**Date:** 18 June 2024

## **The M5 Junction 10 Improvements scheme: Development Consent Order: Relevant representation – Deadline 1**

Comments on Relevant Representations (RR) updated information.  
Further to our formal response on the Relevant Representation (RR) dated 22 March 2024. We have now reviewed the additional submissions which were uploaded to the PINS website dated 23 April 2024 and have the following comments.

Figure 2-2 River Chelt bridge cross-section

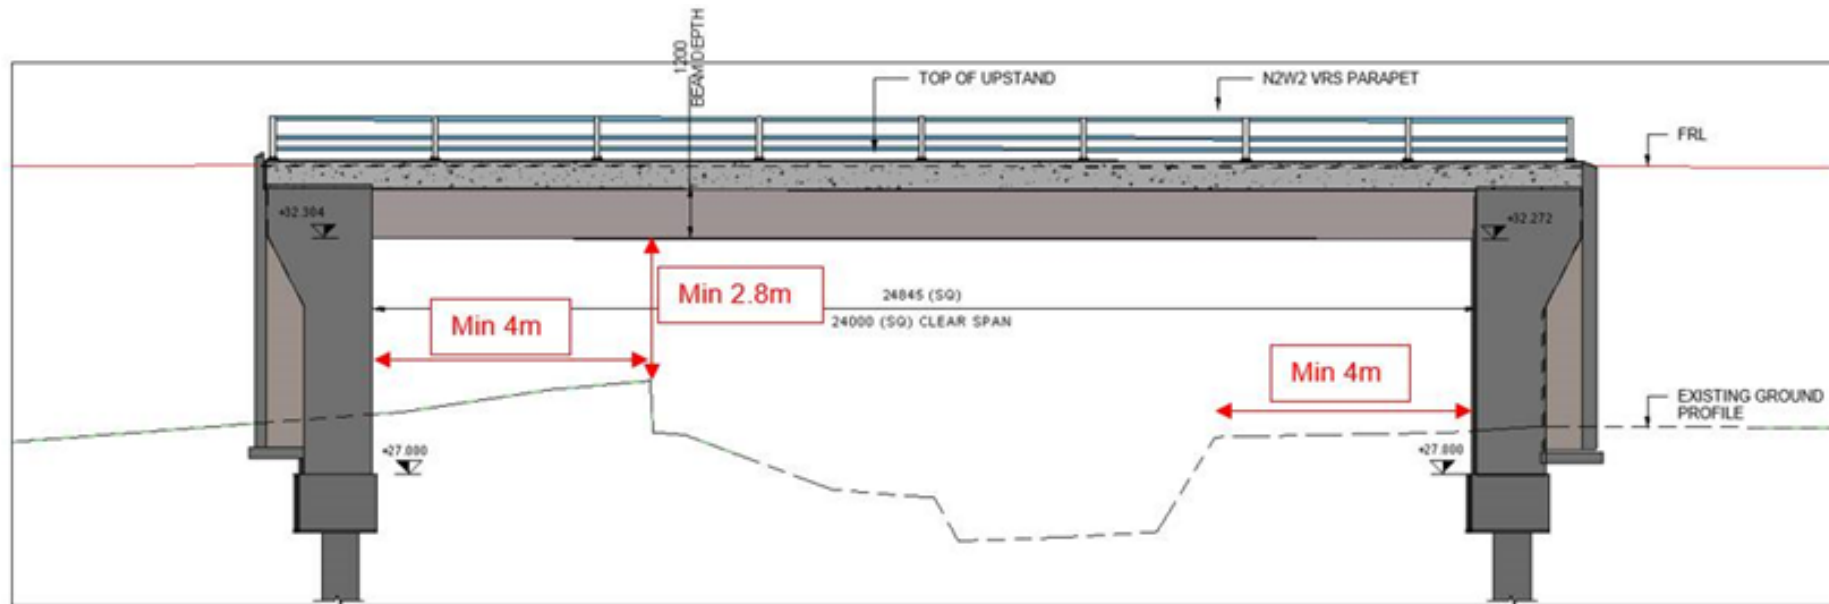
5.1 Bank Erosion and loss of riparian habitat		
Chapter 7: Biodiversity	Issue	It is assumed that hard engineered bank protection will be required underneath the new bridge structure, due to an increased likelihood of bank erosion (caused in part by shading acting to remove bankside vegetation). At this stage, the details of the bank protection have not been determined but it has been assumed that the length will equal that of the width of the bridge deck and comprise of hard bank protection (e.g. rip-rap or non-biodegradable geotextile) as a worst case scenario.
Section/pages/table reference:  7.8.11 and 7.8.12.	Impact	This may cause permanent modification and potential localised loss of marginal lamprey ammocoete habitat.
	Solution	A bioengineered “green solution” would be used to transition from the grey bank protection to the natural banks up and downstream of the crossing. At the detailed design stage, further assessment and consultation with the Environment Agency is required to minimise and, where possible, exclude hard engineered or inappropriate bank protection and maximise habitat compensation.
